DRB Application No.: <u>05DRB-00312 (P&F)</u>	Project # <u>1002047</u>
Project Name: <u>MOUNTAIN RUN SUBDIVISION</u>	
Agent: <u>Tierra West LLC</u>	Phone No.: <u>858-3100</u>

**CITY OF ALBUQUERQUE
PLANNING DEPARTMENT
March 2, 2005
DRB Comments**

RE: TRACT 2 MOUNTAIN RUN SUBDIVISION/ minor plat

Plat of
 Parcels II-A & II-B
**Mountain Run
 Subdivision**
 Albuquerque, Bernalillo County, New Mexico
 November 2004

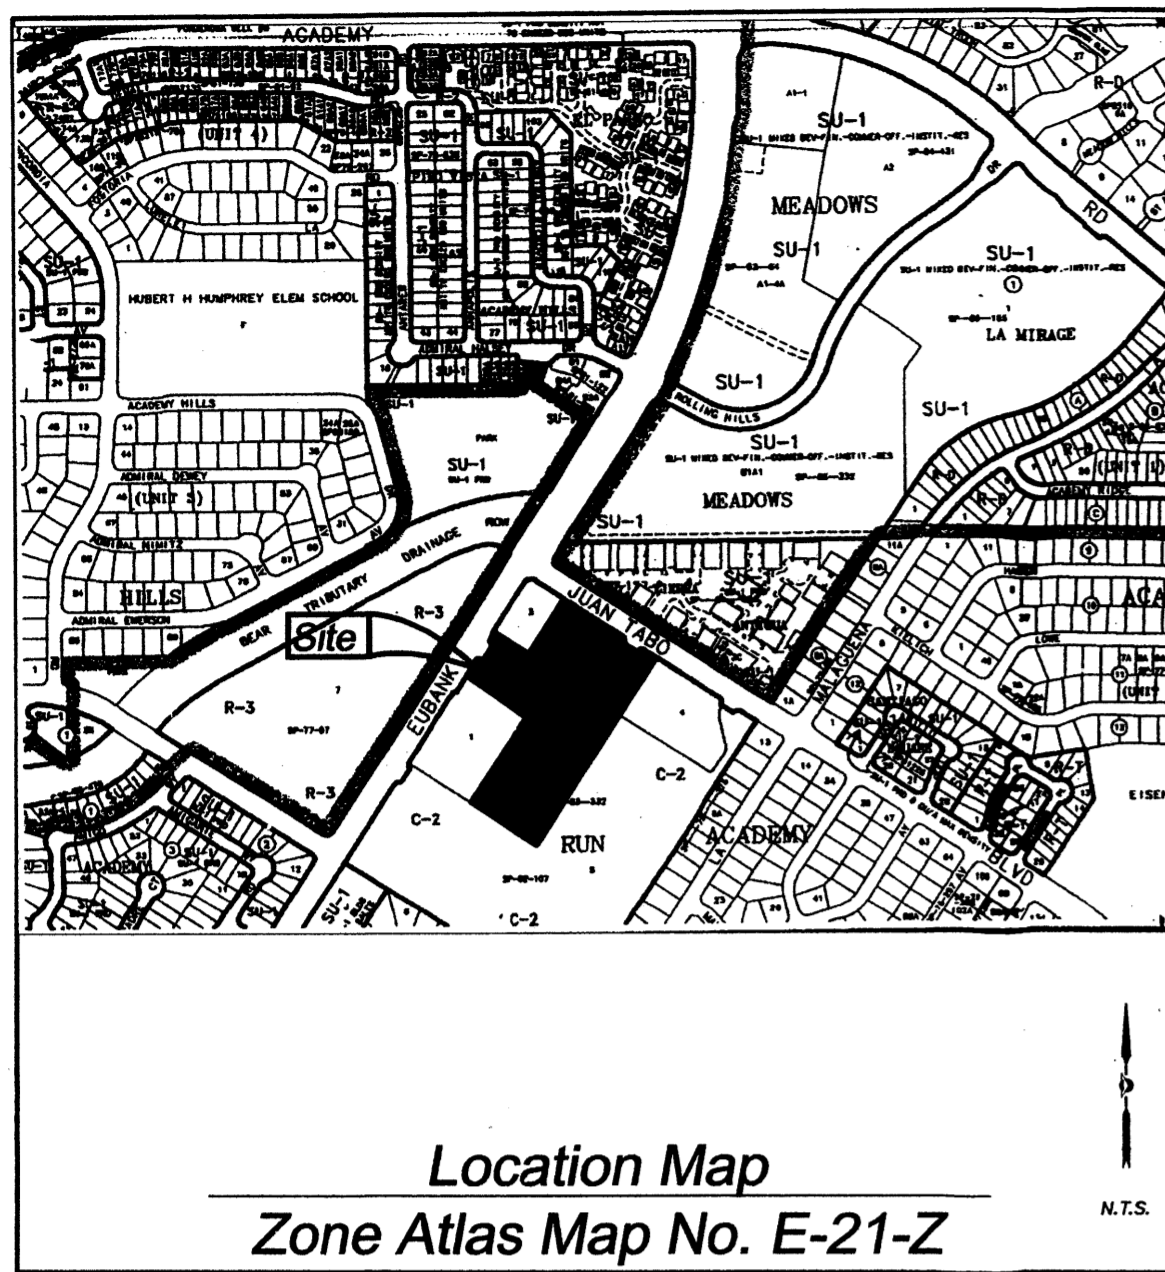
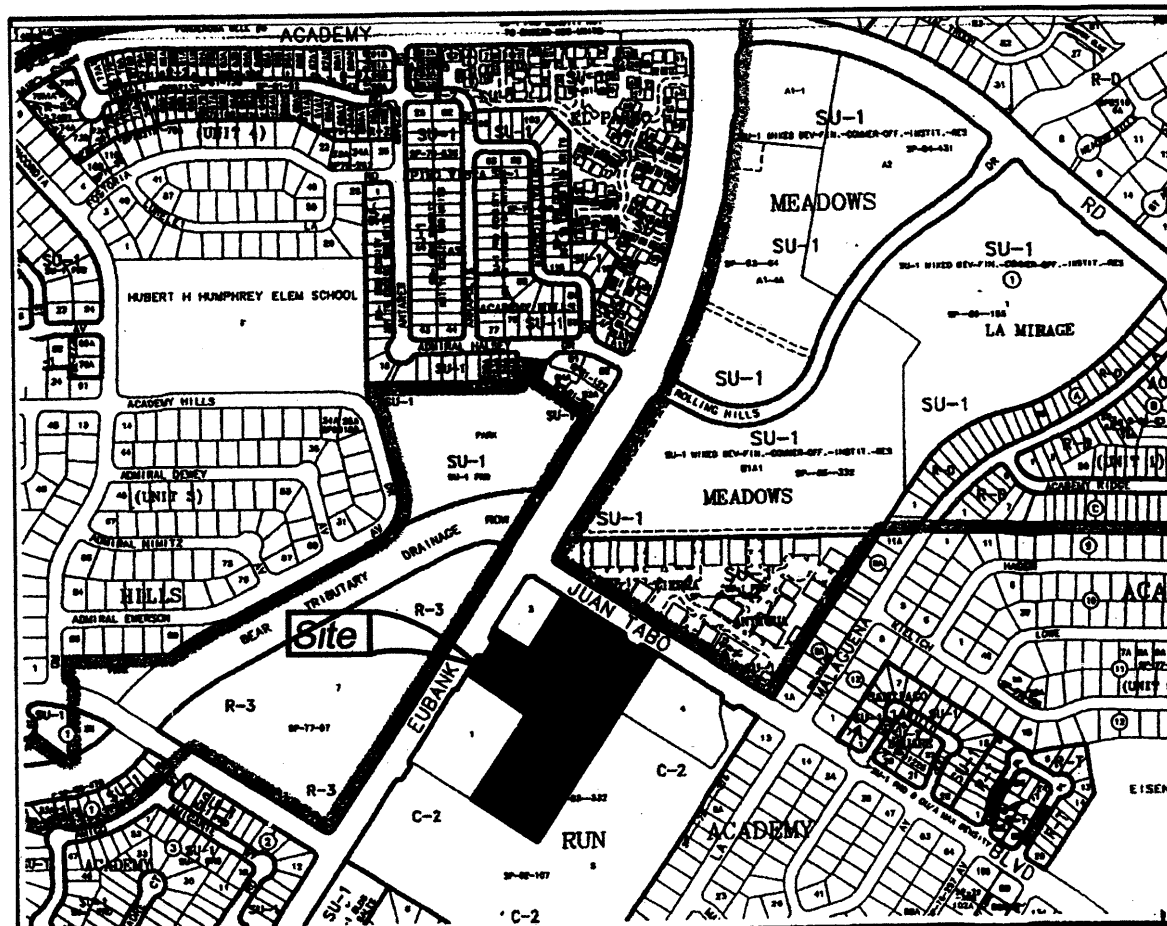
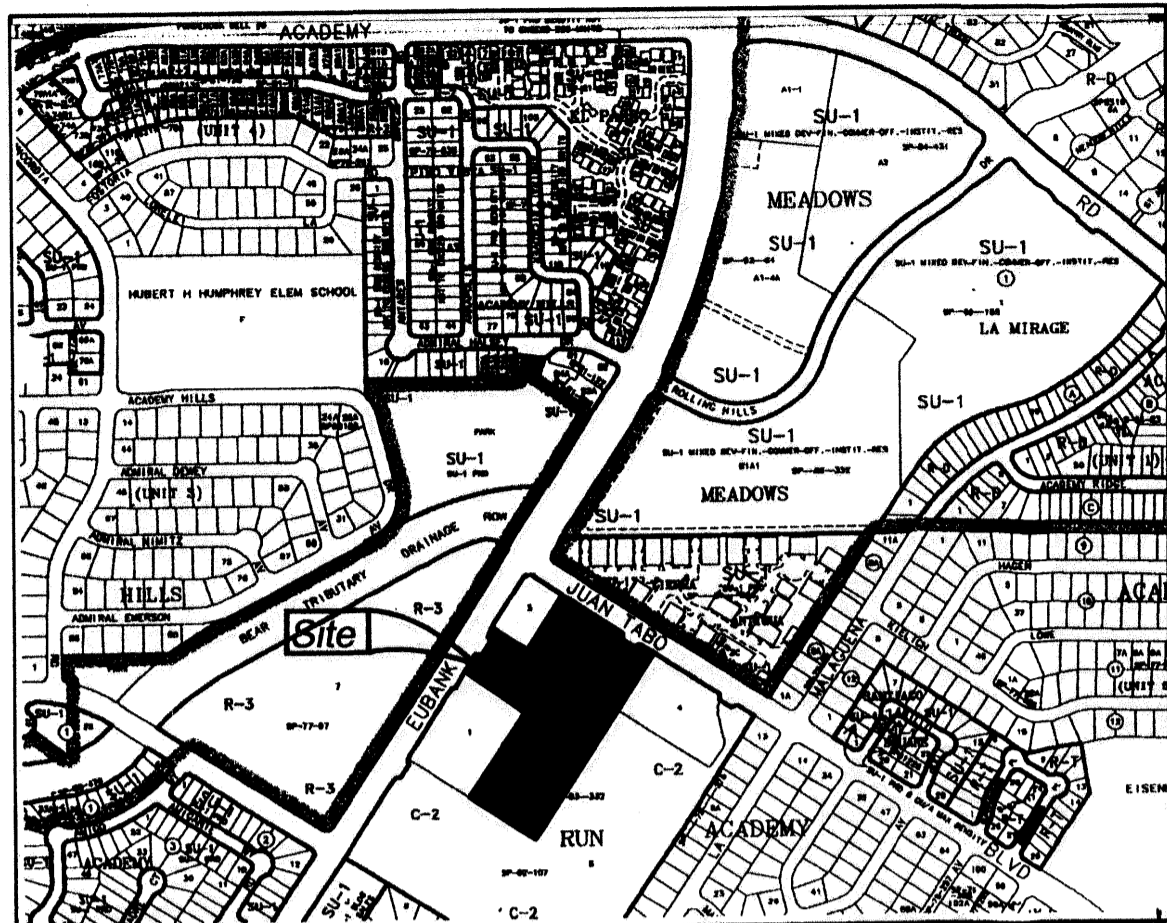
There is no zoning designation on plat data.
